Town & Country Planning Act 1990 (as amended)
Town and Country Planning (Development Management Procedure) (England) Order 2015
Approval of details reserved by condition imposed under ref APP/C3810/A/14/2217385 (AL/61/13/)
relating to Condition No 12 - secure cycle parking.
Nyton Nursery Nyton Road Westergate PO20 3UQ

Condition Number 12

Arun District Council have decided to **APPROVE details reserved by this condition**

DRAWING TITLE: SITE LAYOUT PLAN

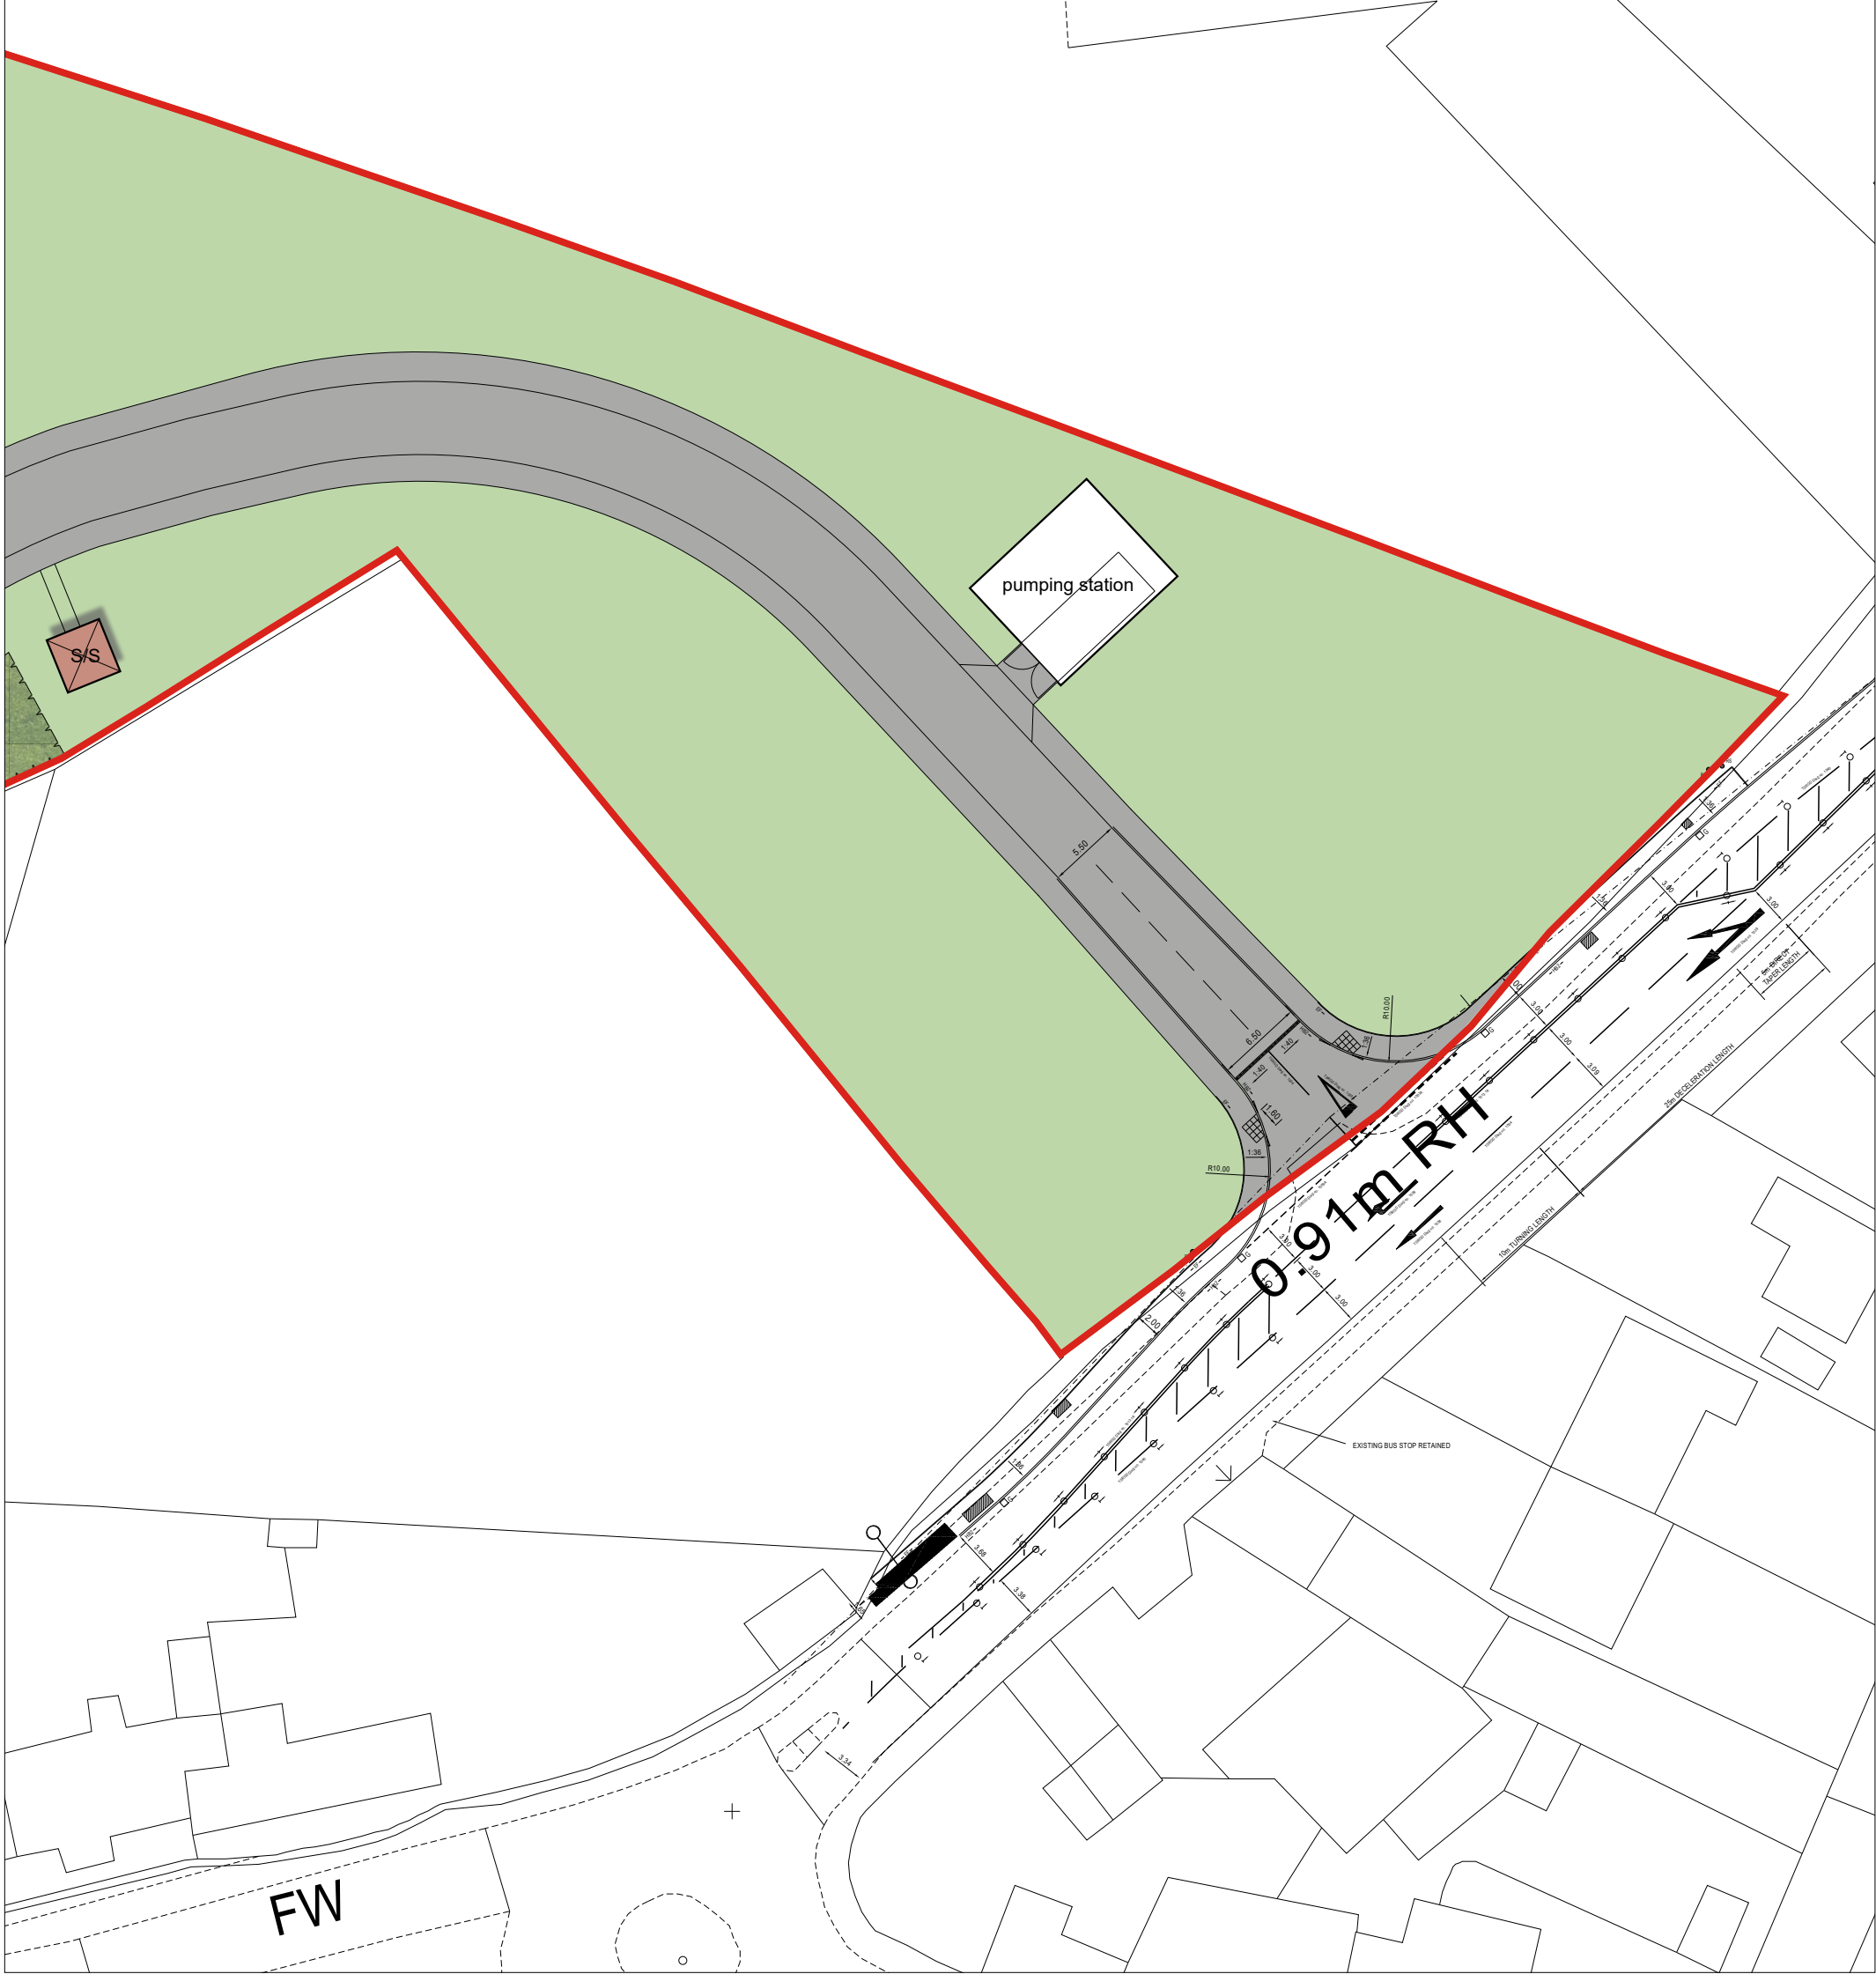
The Site Layout Plan number 59650-101 and schedule identifies the dwellings for cycle storage, together with the specification booklet and Plan number WSC-A-4673-APT-20 identifies the cycle storage on the block of flats which meets the requirements of this condition.
